# GRADING AND EROSION CONTROL PLANS FOR WALDEN SANITATION DISTRICT WASTEWATER TREATMENT PLANT PROJECT EL PASO COUNTY, COLORADO MARCH 2026

PCD PROJ. NO. : PPR2538

SHEET TITLE: OVERALL SITE PLAN		
PROJECT NUMBER: #3774	SCALE: 1"=60'	SHEET: C3

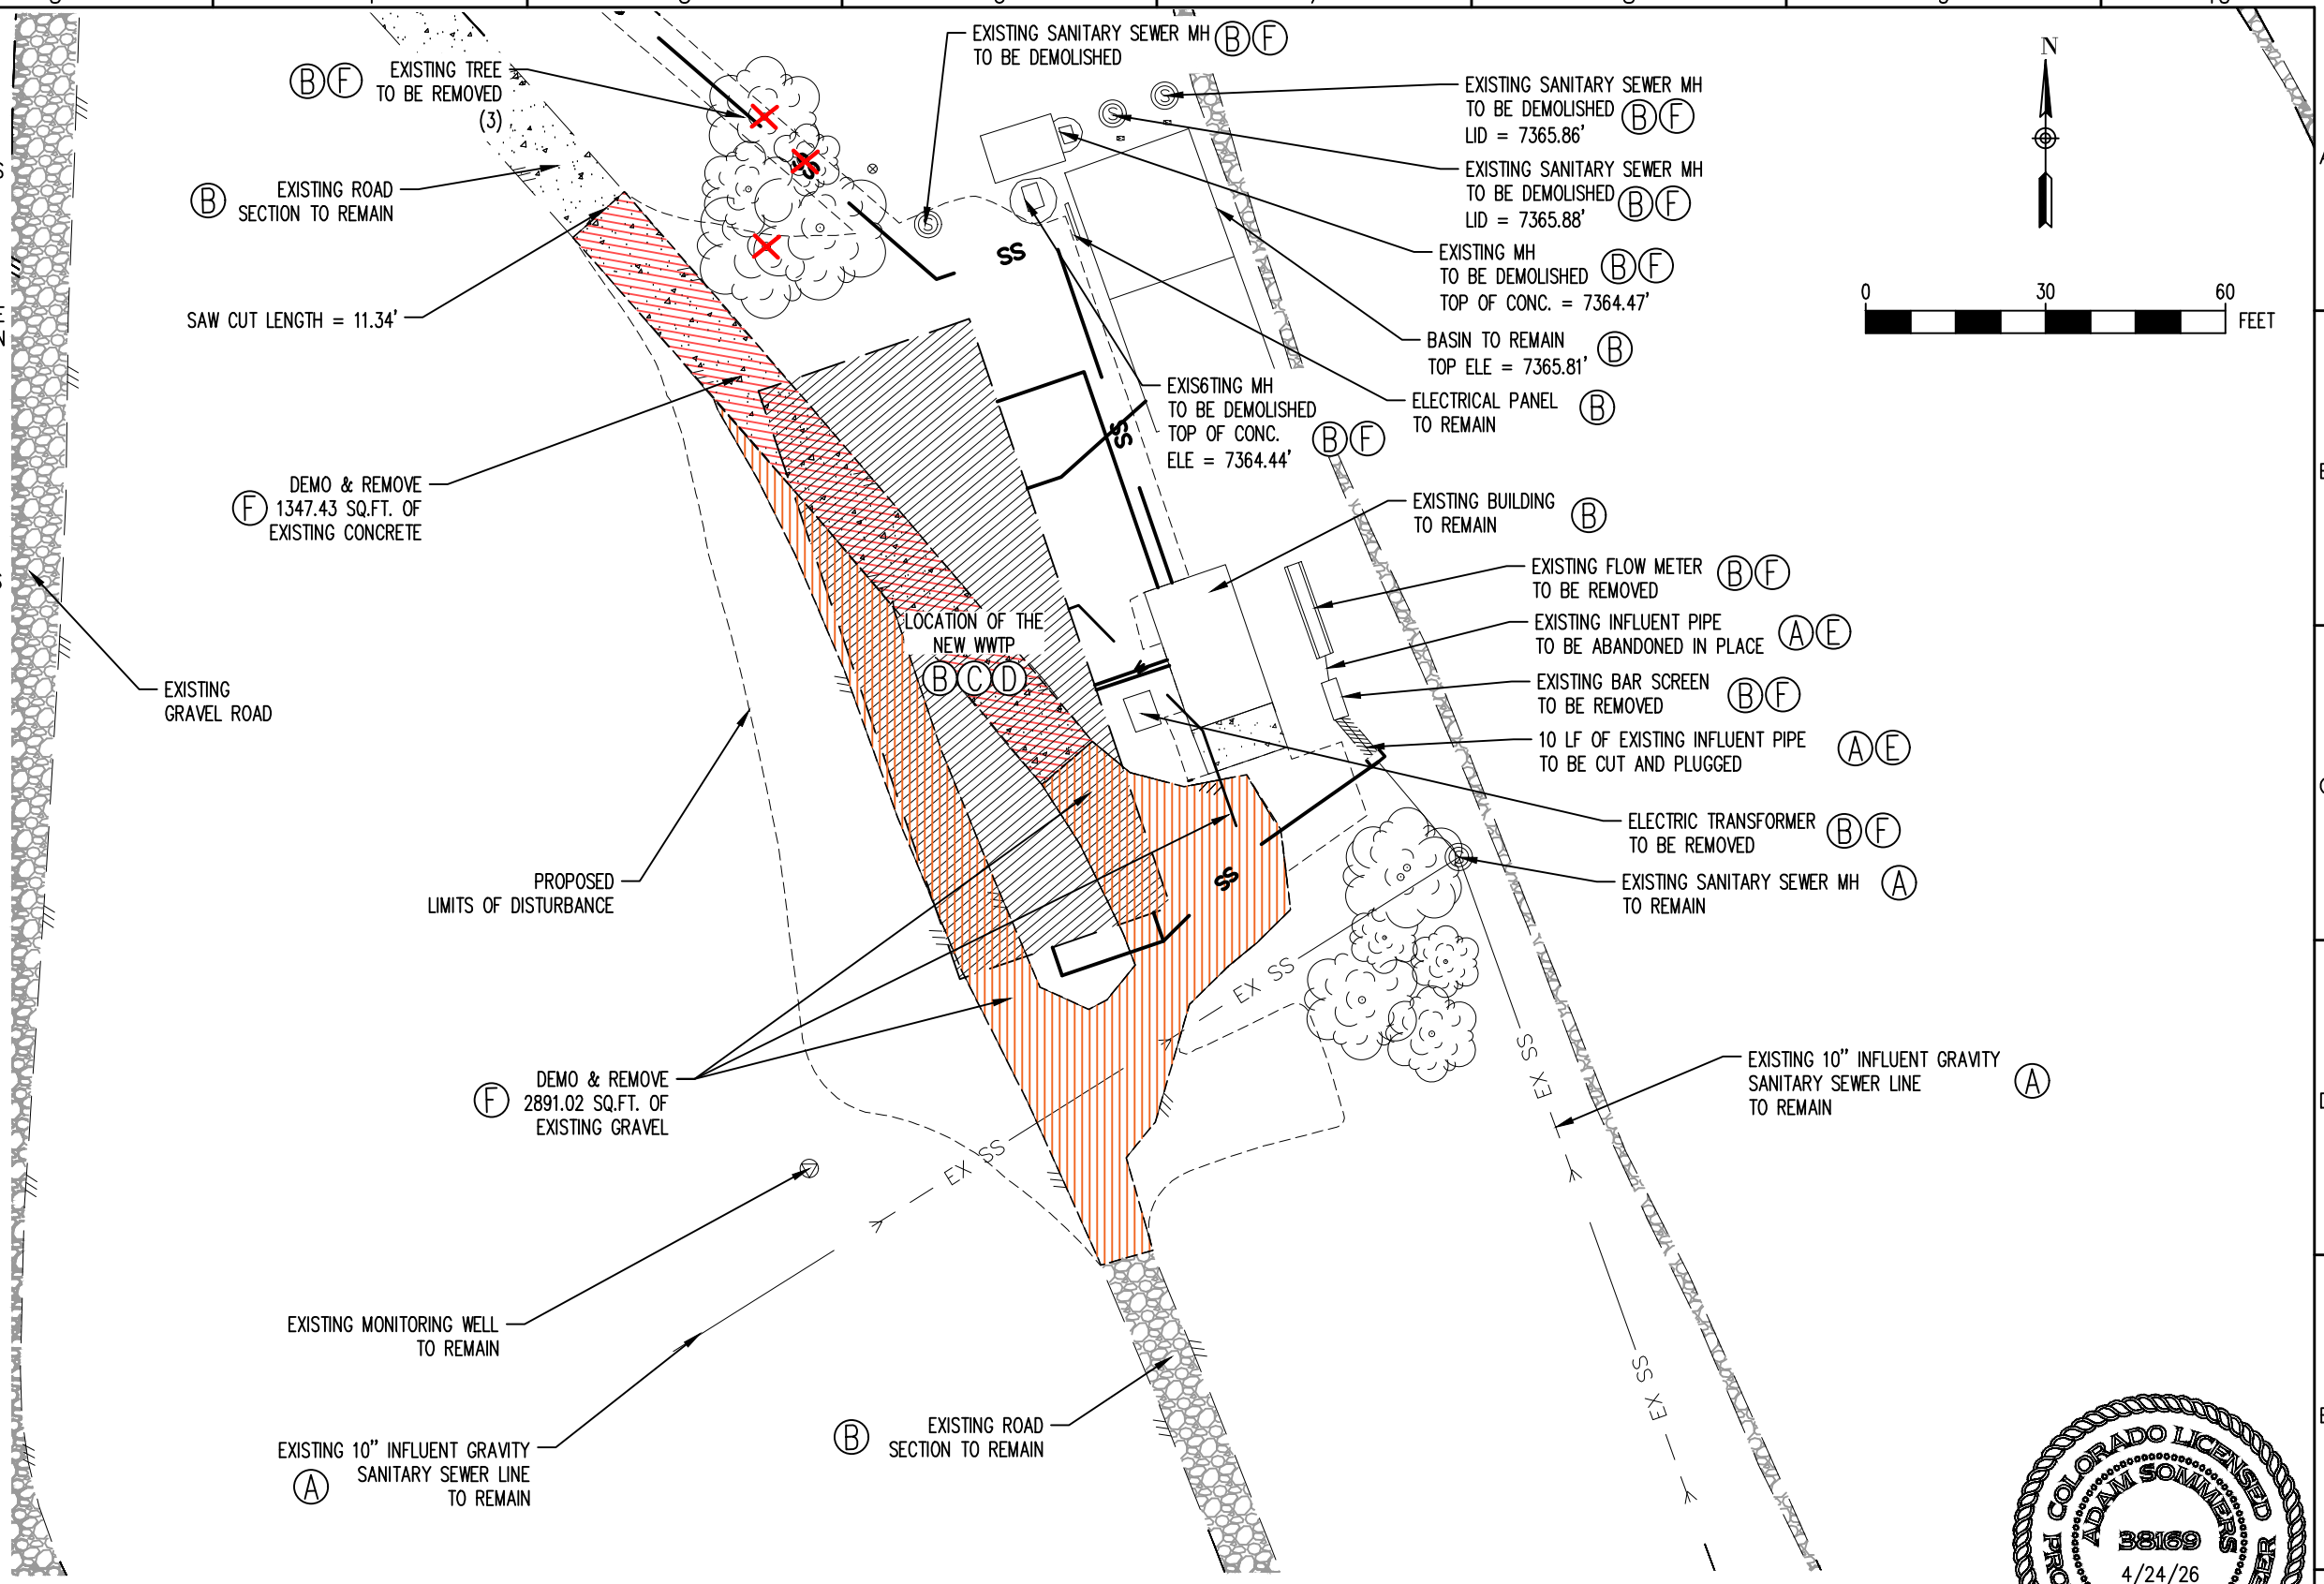
EPC DPW Stormwater did not fully review the last GEC submission since it was not associated with a stormwater permit. New information provided with this submission has triggered the requirement for an ESQCP, so full comments will be provided at this time. See comment on sheet 12 for additional information.

If "limits of disturbance" and "construction boundary" are the same, change to "limits of construction/disturbance" or otherwise show as separate line types for each on the legend and figure.

"Limits of disturbance" and "limits of construction" were shown as separate, on legend and figure. Updated the name from "disturbance boundary" to "limits of disturbance"
